Your ref: SSD 7228  
File no: MC-15-1942

**Re: SSD 7228 Sydney Zoo, Bungarribee Park, Western Sydney Parklands**

## **ATTACHMENT A**

BIORETENTION SPECIFICATION

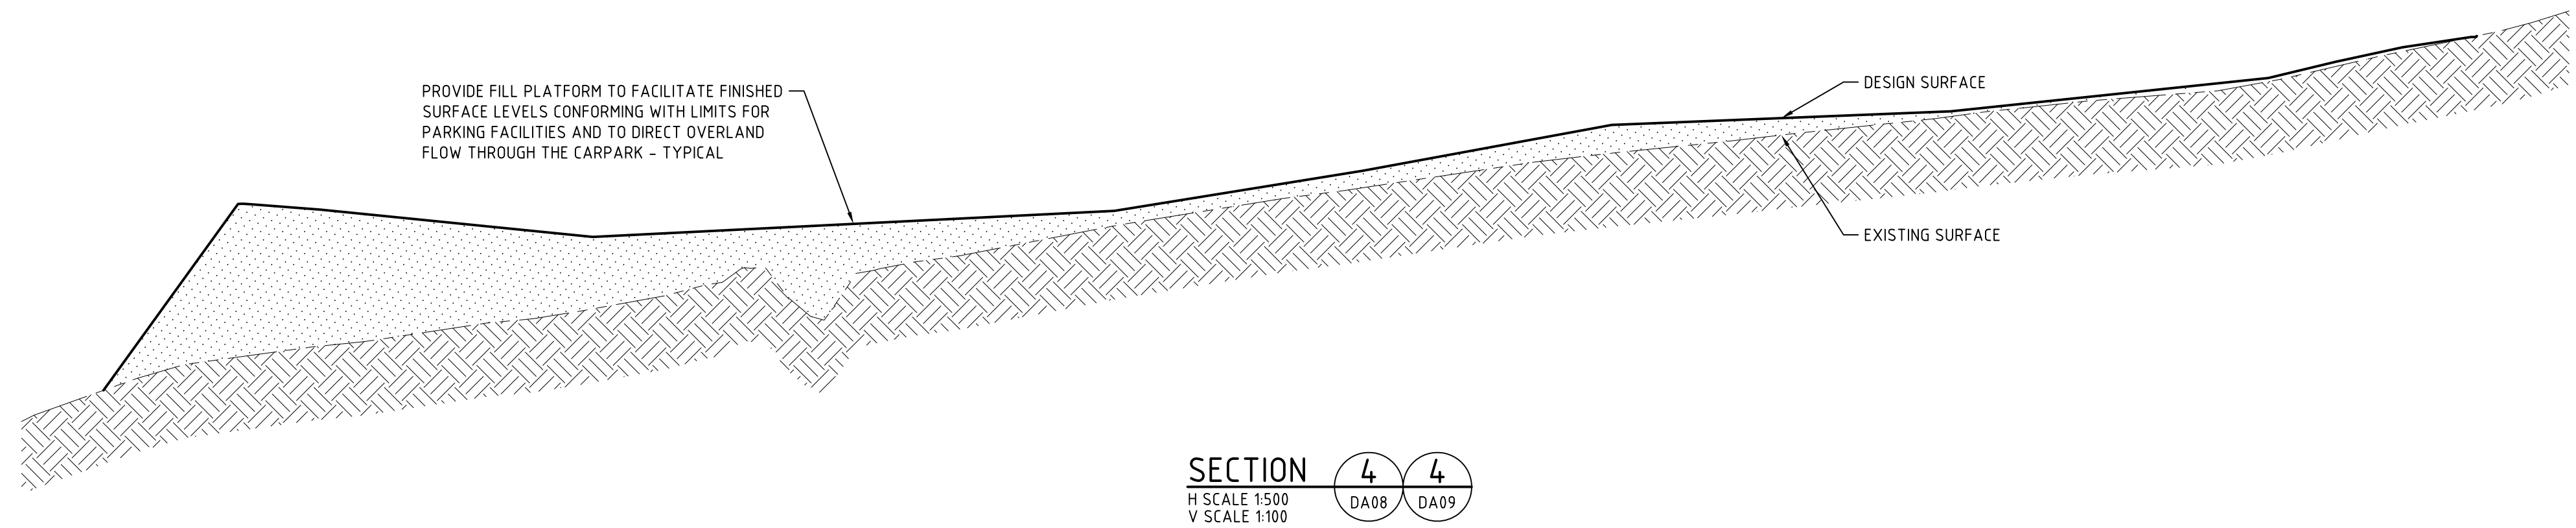
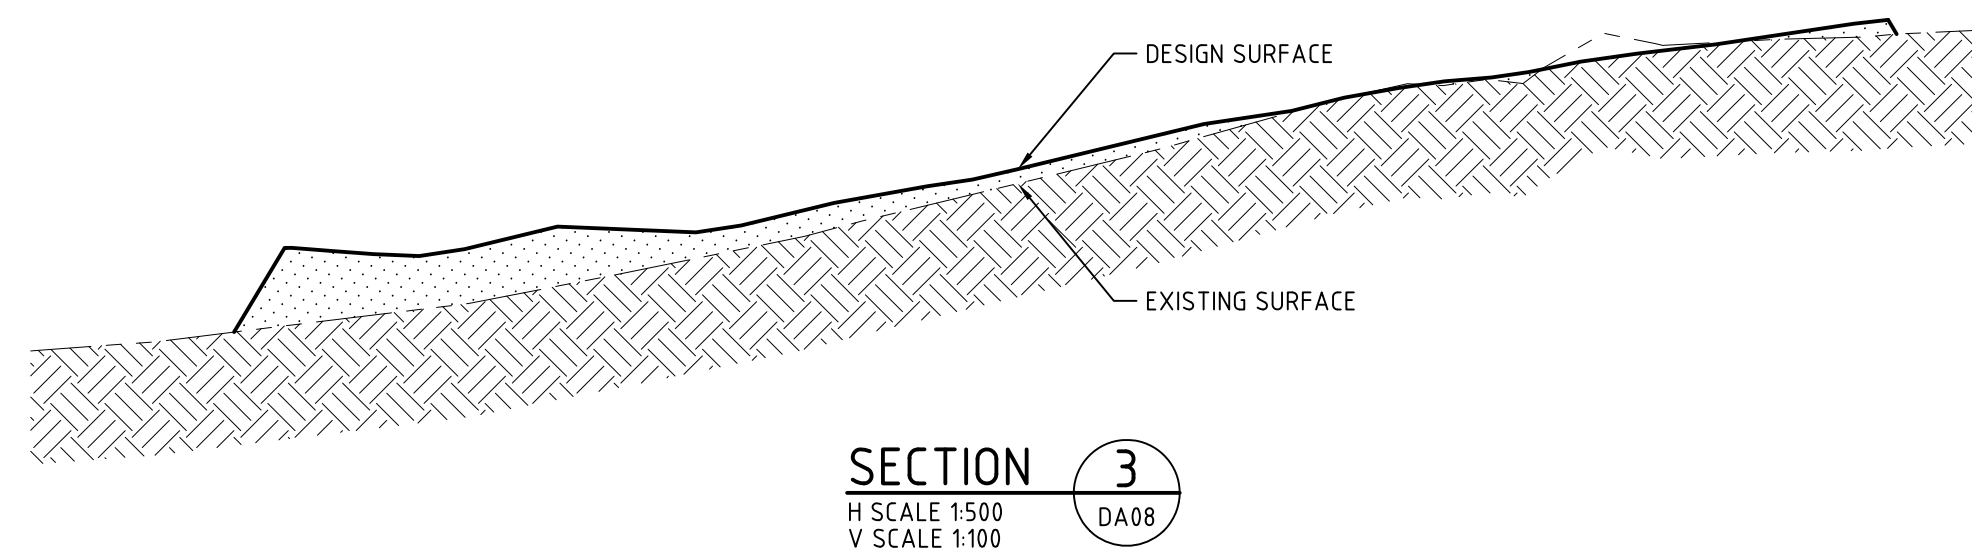
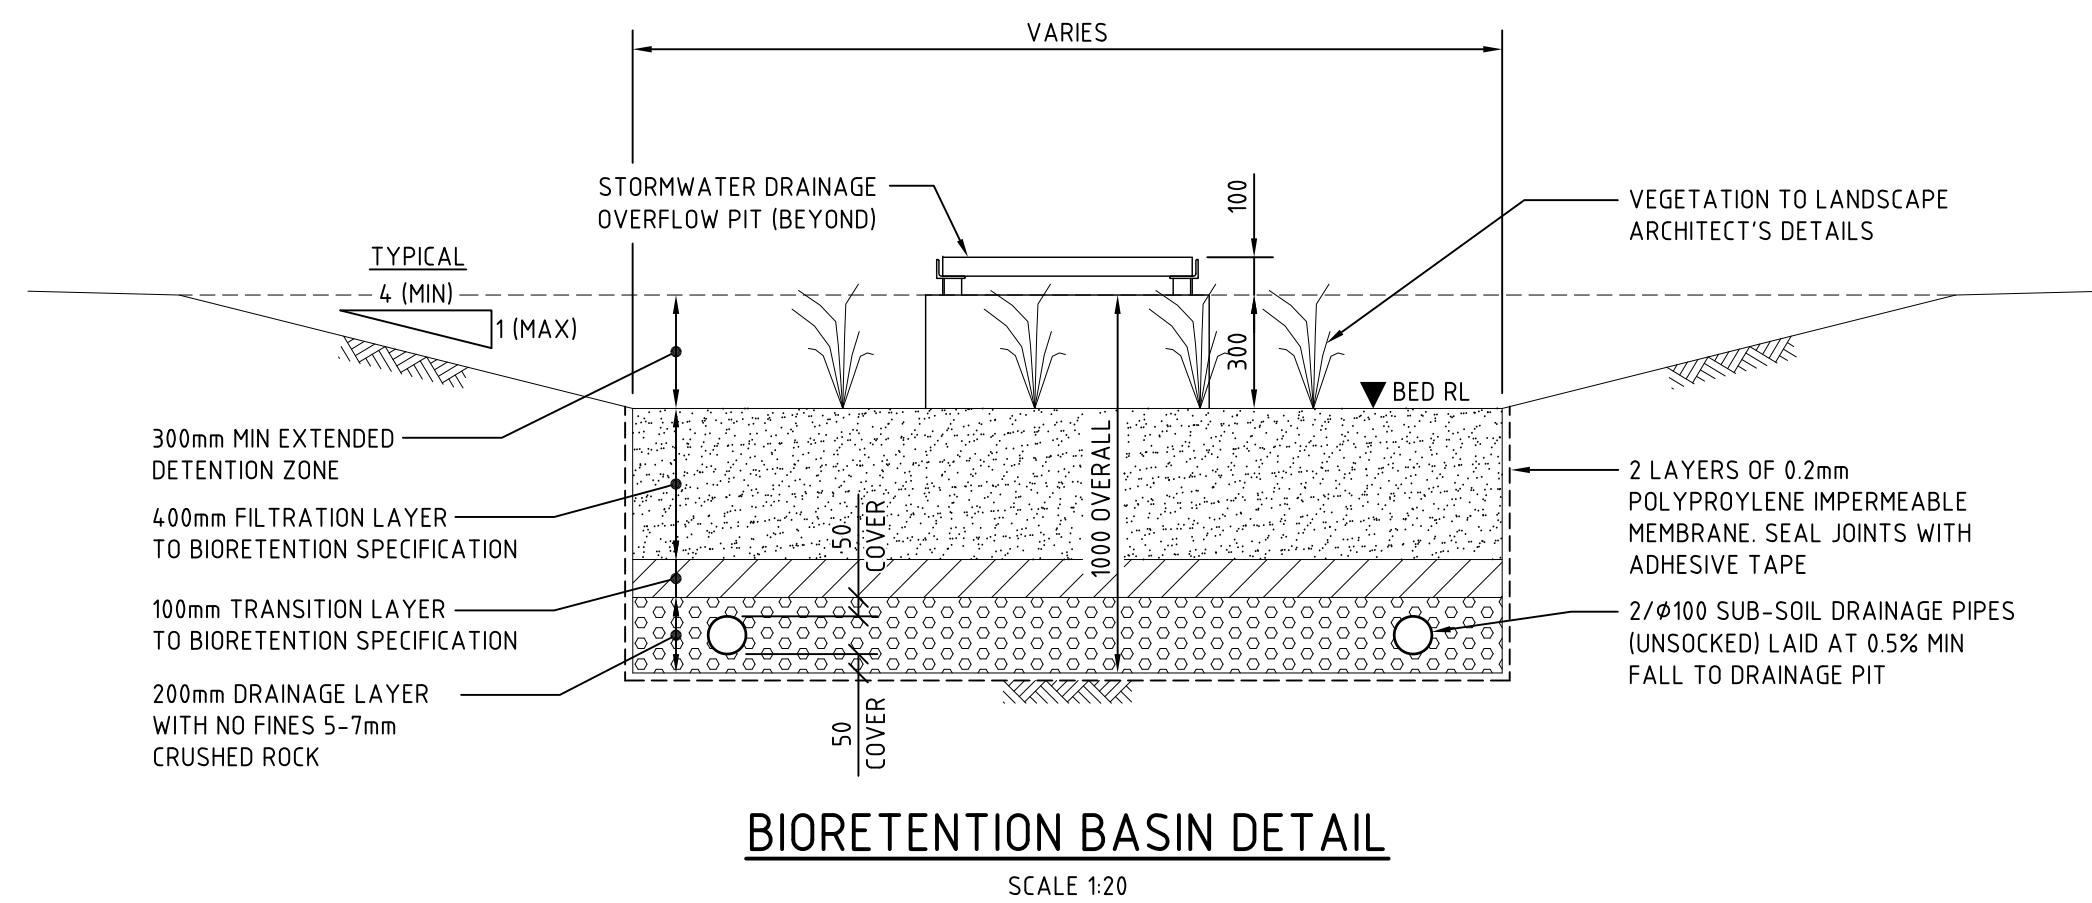
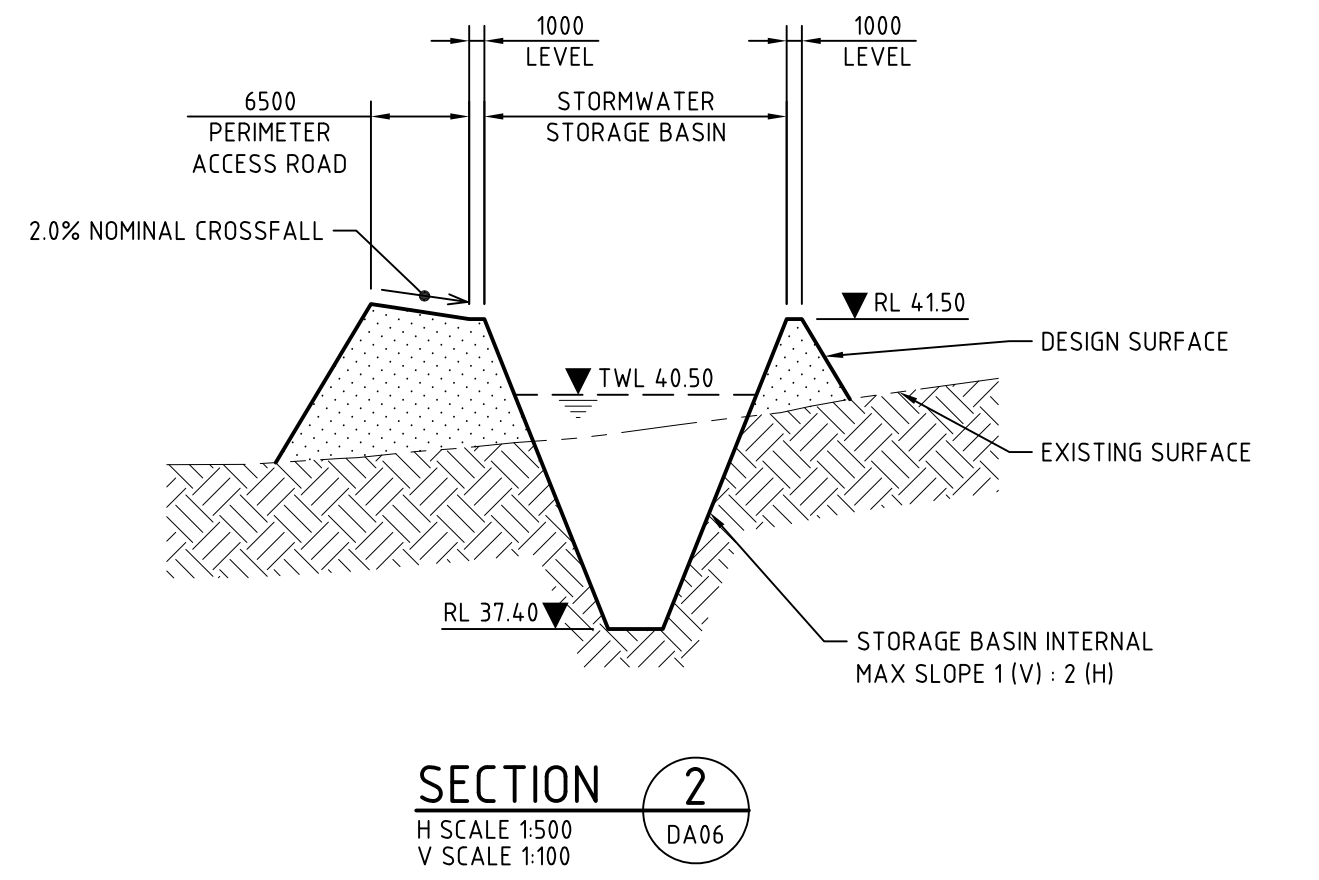
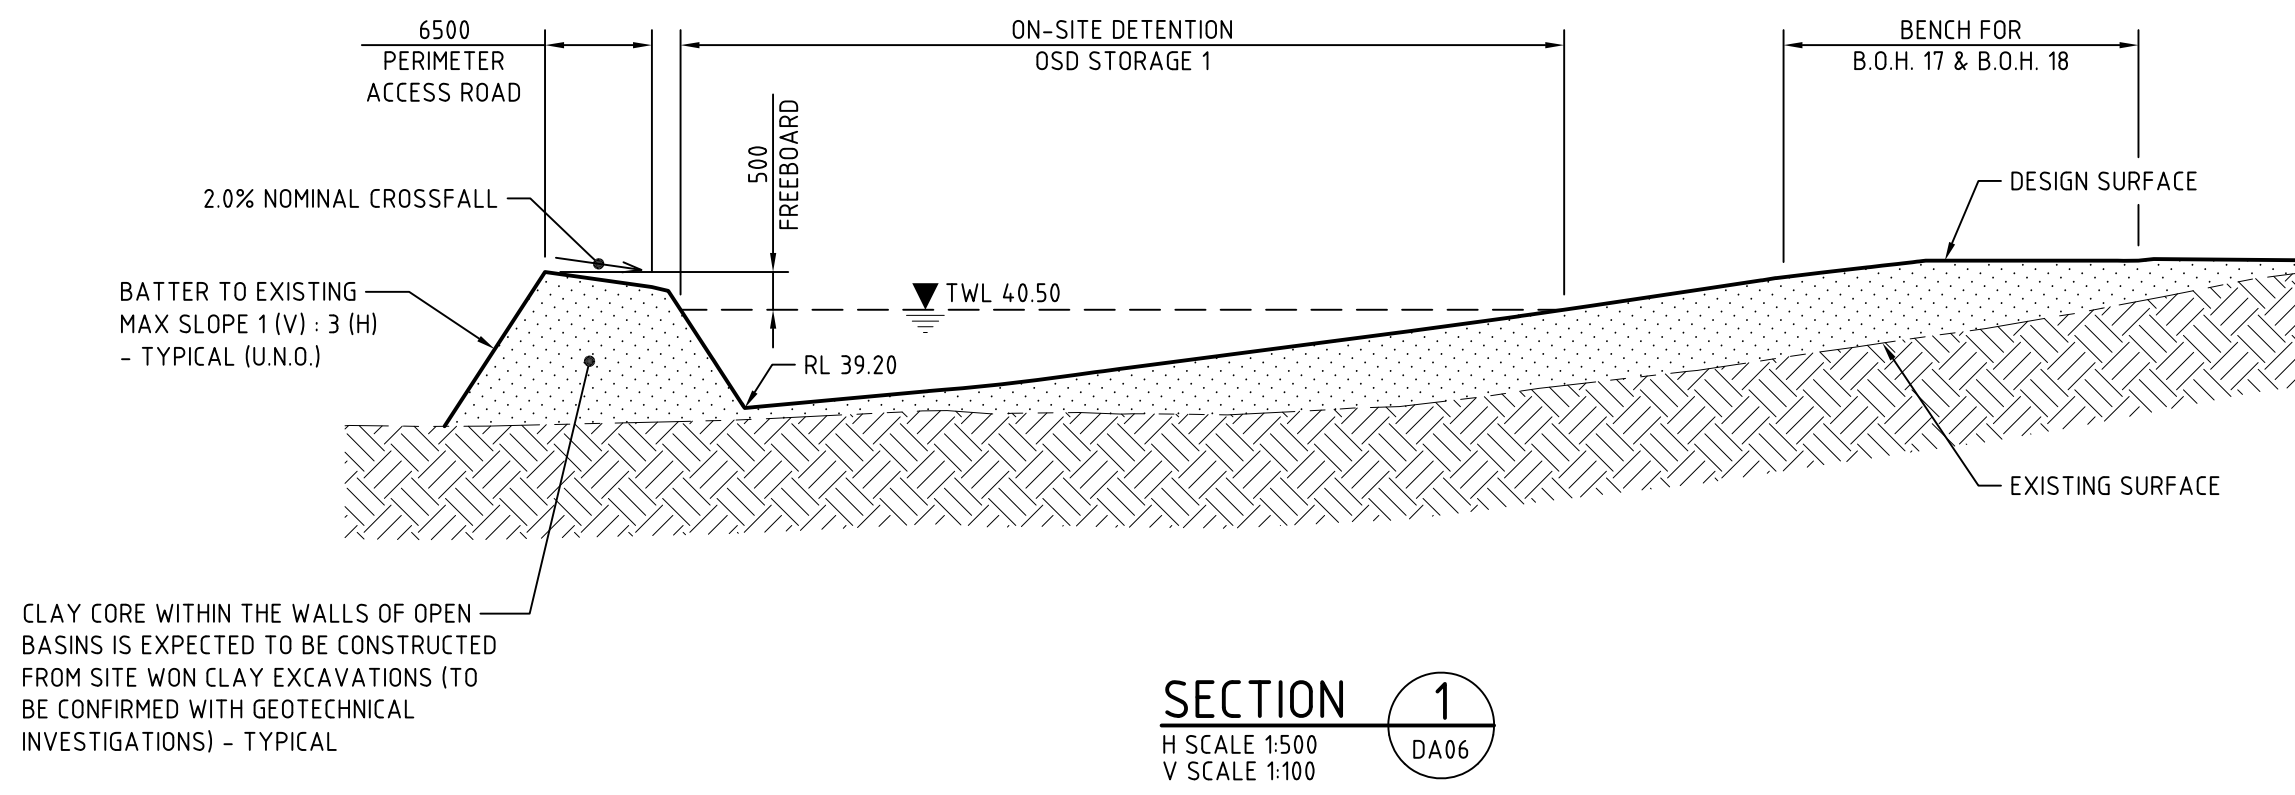
- 32.** Amended Concept Drainage Plans from Lindsay Dynan must address the following:
- i. The bioretention areas are scattered throughout the development. To ensure effective operation each basin is to be designed to ensure an absolute minimum filter area of 1.7% of the catchment area draining to it. Each basin is to be designed for maintenance and ensure vehicular access for future system replacement.

- ii. Provide an intermediate riser detail for long subsoil lines, or subsoil collection pipes at maximum 20 m intervals.
  - iii. Provide a detail of a subsoil riser for flushing and maintenance of the subsoil collection pipe. The riser is to include two 45° bends with a short section of un-slotted straight (minimum 300 mm) in between. The vertical riser is to stop 50 mm above the extended detention depth and sealed with a removable screw cap.

- v. All outlets to the bioretention basin must be daylighted with pipe inverts at or above the filter level and no surcharge pits are permitted.
  - vi. Provide scour protection for the piped discharges into the bioretention area. Provide calculations or supporting nomographs.

- vii. Provide a Raingarden Sediment Pit as part of the scour protection for the piped outlets to all the bioretention basins. This pit is to include a minimum 400 mm deep silt trap to protect the filter material from clogging. The concrete top of pit is to be set to the filter media level with a surcharge style grate over or surrounded by railings. The subsoil seepage drainage is to be directed through the side to the bioretention filter media, or transition layer, but not to the gravel layer.

- viii. Provide a detail of the overflow pit from the bioretention basin. The grate is to be a raised park or surcharge style to minimise blockage. The pit size is to be increased such that depth of weir flow into the pit for the 1 in 100 year ARI event is a maximum of 100 mm, assuming 50% blockage.
